Independent Technical Planning Review

Prepared on behalf of Wilpshire Parish Council

Proposed Residential Development at Salesbury View, Wilpshire

Final Issue – July 2026

Figure 4: Landscape Masterplan

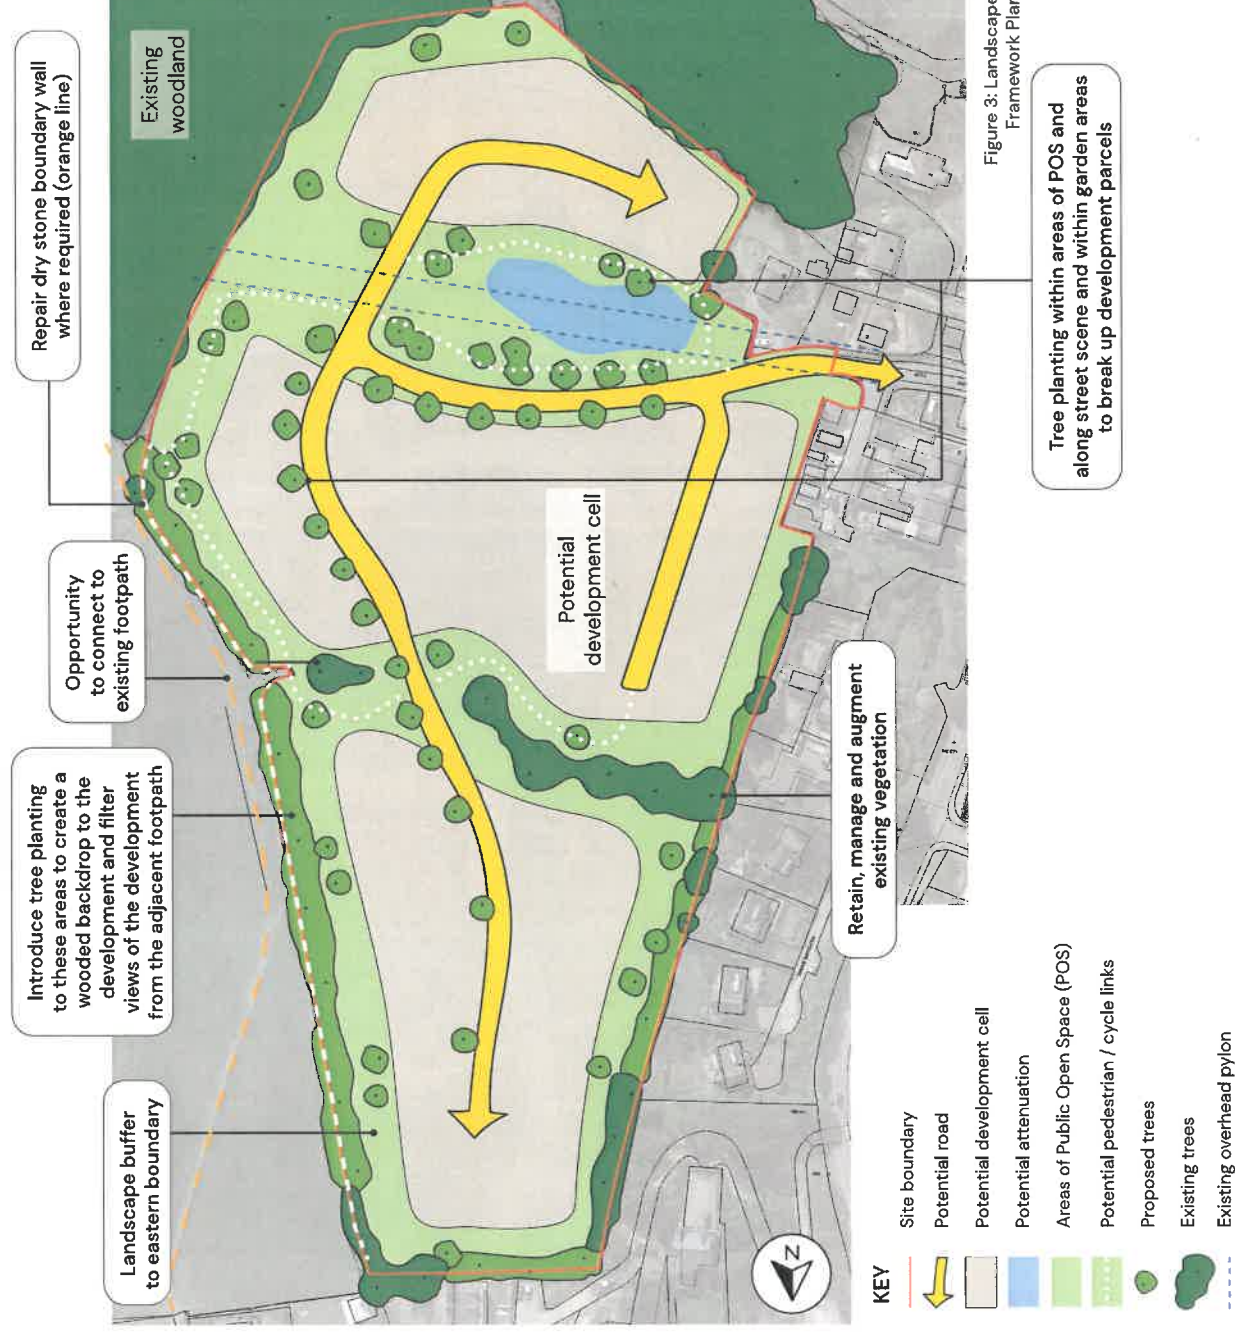
This wider landscape relationship is illustrated by Figure 1 – Landscape Context (p.6), whilst Figure 2 – Proposed Site Layout (p.7) and Figure 4 – Landscape Masterplan demonstrate that the revised proposal continues to occupy and develop the same transitional landscape.

Whilst the principle of residential development has been established through the allocation of the site, the evidence reviewed does not demonstrate that the revised proposal has fundamentally altered that underlying relationship. Whilst amendments have been made to individual elements of the layout and landscape strategy, the proposal continues to rely upon development of this transitional landscape, with the submitted evidence indicating refinement of the development response rather than a fundamental change to the site's relationship with the surrounding landscape.
